From: Jean Fraser
To: Jeff Materazzi
CC: Amanda Schultz; Christina Stacey
Date: 12/21/2015 11:10 AM
Subject: RE: Conditional approval RE: Permit #2697 - Irving Oil, 2282 Congress St, Portland, ME
Attachments: IMG_0520_1.jpg

From: Jean Fraser [mailto:JF@portlandmaine.gov]
Sent: Friday, December 18, 2015 4:45 PM
To: Amanda Schultz <aschultz@prosign.net>
Cc: Christina Stacey <CSTACEY@portlandmaine.gov>; Jeff Materazzi <jmaterazzi@prosign.net>
Subject: Conditional approval RE: Permit #2697 - Irving Oil, 2282 Congress St, Portland, ME

I am writing to confirm that your request for a waiver of the sign ordinance provisions, in respect of the building signs, canopy signs and one pylon sign near Congress Street, have been reviewed under section 14-526 (d) (8). The Planning Authority has determined:

O-1 | Main ID Overview
Scale | NTS

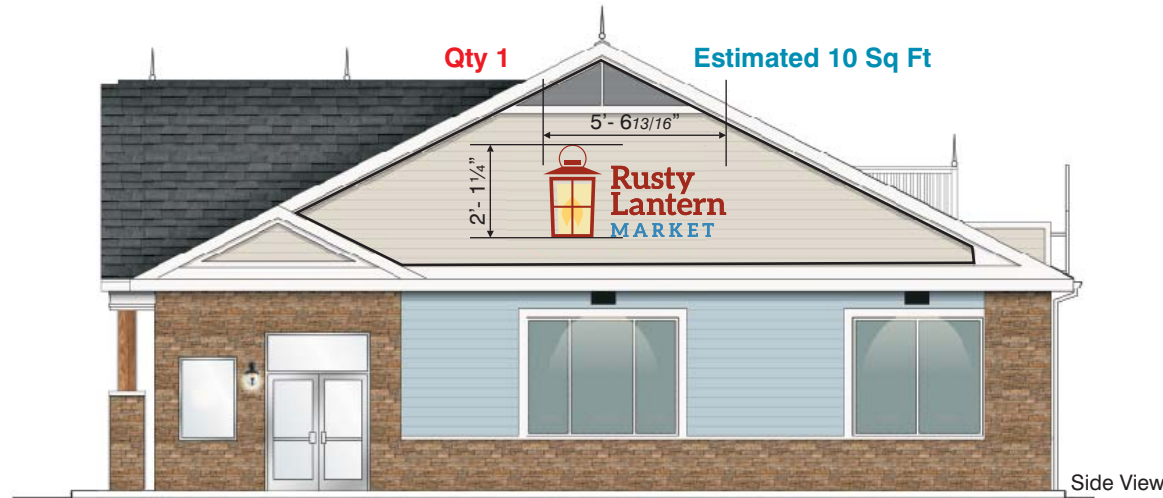
Could you help me understand why this is important, as it brings the project to 4 feet higher than our standard.

I thought the photo of the sign without that panel (see attached) looked much more in proportion. The blue is very thick in section so to have so much of it seems overscaled. In Portland Maine we don't have any gas station signs of this scale. With the LED lights it is already going to be very intrusive.

The gas station use is not allowed in the zone where it is located and was only granted as a Conditional Use (CZA) that was approved by the City Council. The CZA requires a "campus like setting" and that stretch of Congress Street generally does not have big signs and we have sought to achieve a campus like feel all along it with alot of mature trees etc..

The waiver criteria are based on making exceptions because of unique circumstances and in this case I am not seeing much that is unique except that the sign is somewhat distant from the actual gas station. However, if there is a reason for this extra panel I am willing to look at it again. We have already allowed almost 2 feet above the standard because there is a market in this project and that needs to be signposted.

one pylon sign near Congress Street: that the proposed pylon sign (plan dated 12.7.2015 as attached) does not meet the waiver criteria for 2 reasons:
it includes advertising (lowest panel) that does not signpost a separate or particular use on the site there is no need for the extra 4 feet in height, which taken together with the thick blue section is over-scaled.

We will grant a waiver for the pylon sign subject to the following conditions:
that the bottom panel is removed (that refers to "save on gas" with card shape) and the remaining upper section is lowered by 2' 2.5" giving a maximum height of 19.8 feet (with no change to the distance of the sign from the ground, which has been reviewed in relation to sightlines). The 19.8 feet represents a waiver being granted for the increase of 1.8 feet above the standard. This waiver reflects the unique characteristics of the site which limit the location of the sign to a short section of the frontage some ways from the rest of the gas station development; and that although the sketch site plan shows two pylon signs on this site, only one pylon sign has been approved (as outlined above) for the one nearest to Congress Street.
